File: SF17/25766  
Job ID: DOC17/310543  
Your Ref: SSD 7894

**RE: Heritage Council comments on the Proposed Chau Chak Wing Museum at the University of Sydney (SSD 7894)**

View Comparisons

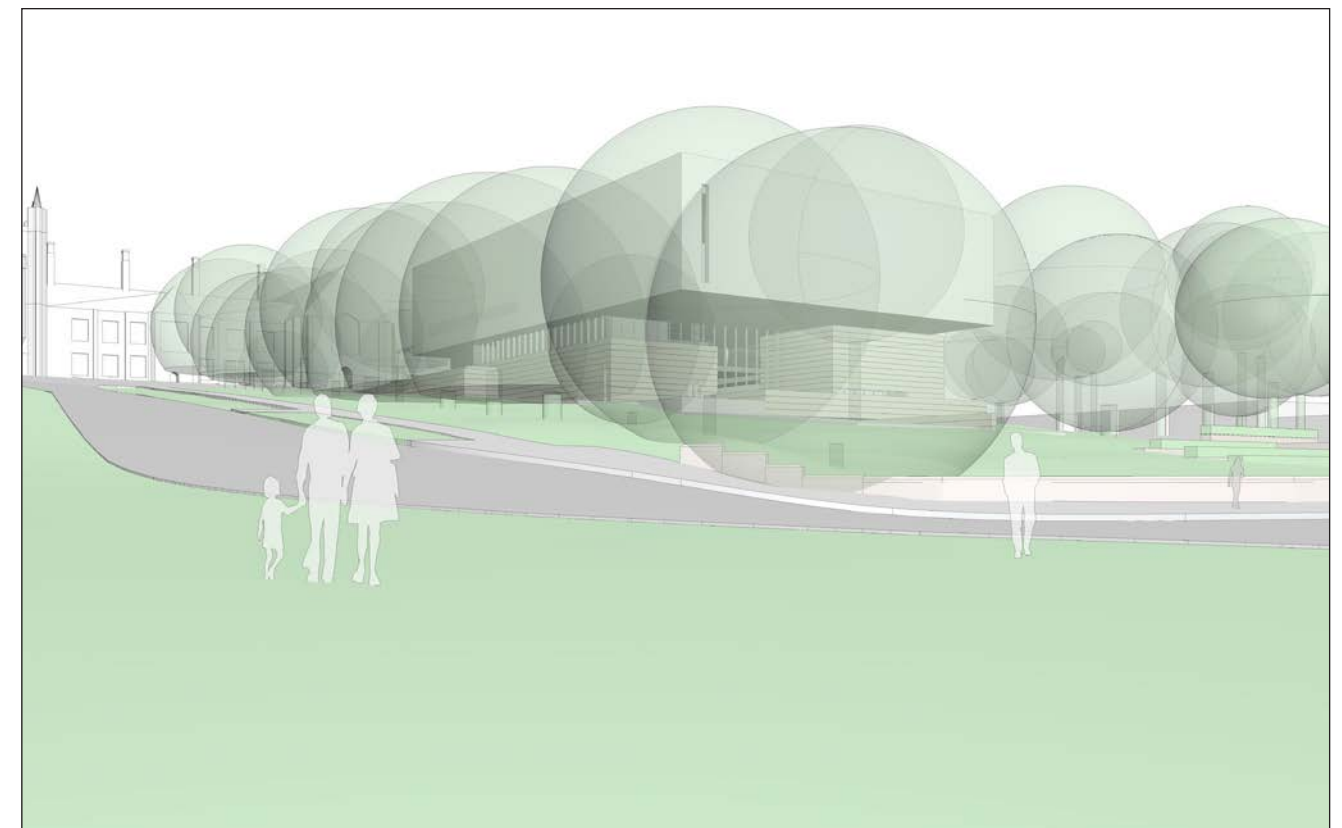
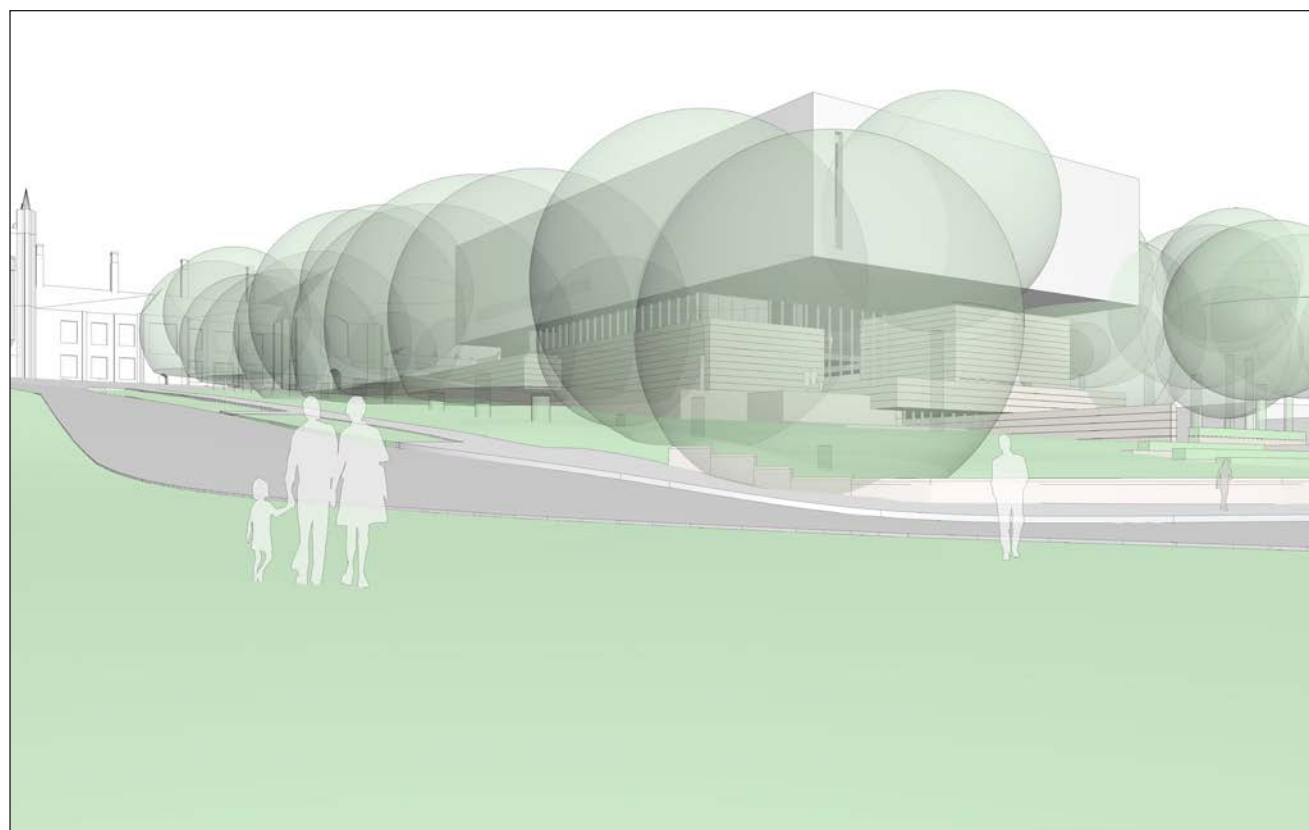
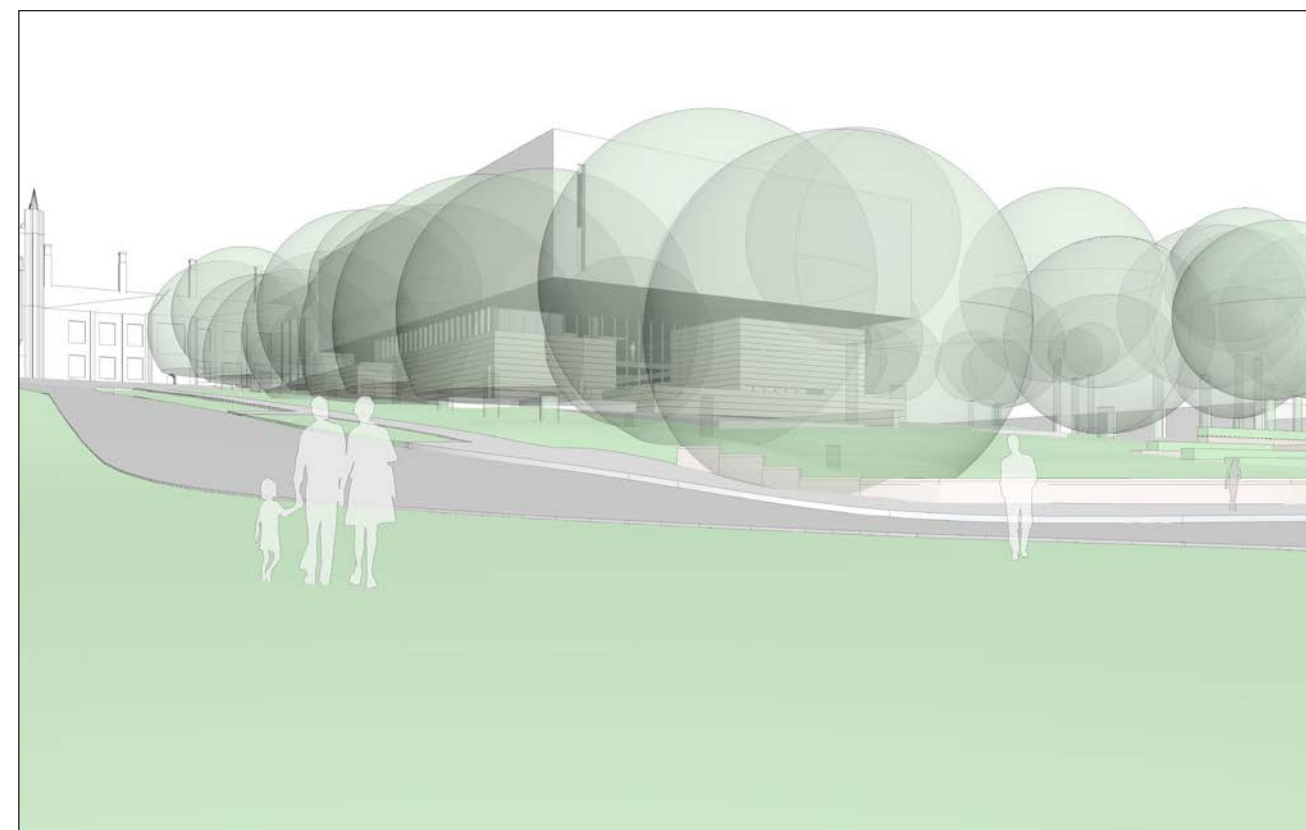
- On 7 December 2016 preliminary designs for the Chau Chak Wing Museum were presented to the Heritage Council Approvals Committee, which provided the following comments for the proponent:
  - a. The design of the building, if built in the proposed location, has to be a counterpoint for the gate house (Baxter's Lodge), which can be viewed in the round.
  - b. The design should be carefully thought out and sit comfortably within the site with high quality details and finishes.
  - c. The design of the loading dock, in particular, will need to be carefully resolved to avoid utilitarian design outcomes for the eastern elevation opposite the gate house (Baxter's Lodge).
  - d. The Heritage Council looks forward to an update in early 2017.
  - e. The maximum height of the building should take its cues from the height of the surrounding trees as viewed from the Great Hall.

The Heritage Council expressed concerns at the first review that possibly this site is *not considered an appropriate area to site a building*. The documents supplied have been reviewed and the proposal cannot be supported. Visual Assessment has been requested by the Heritage Council from the first review of the proposal, the most recent being from the Heritage Council Approvals Committee at the presentation of the concept design on 1 March 2017, in particular, requesting a *view towards the loading dock entry from Baxter's Lodge* (View E). This photomontage confirms the concerns raised by the Heritage Council that the impact of the loading dock, located at the main entry to the University is unacceptable. It is not designed as a counterpoint for the gate house (Baxter's Lodge). The design does not sit comfortably within the site. The design of the loading dock is not well resolved and the utilitarian design has an unacceptable impact on the heritage values of the site.

It is requested that the applicant be required to consult with the Heritage Council and amend the proposal accordingly to resolve these issues prior to any further approval being granted.
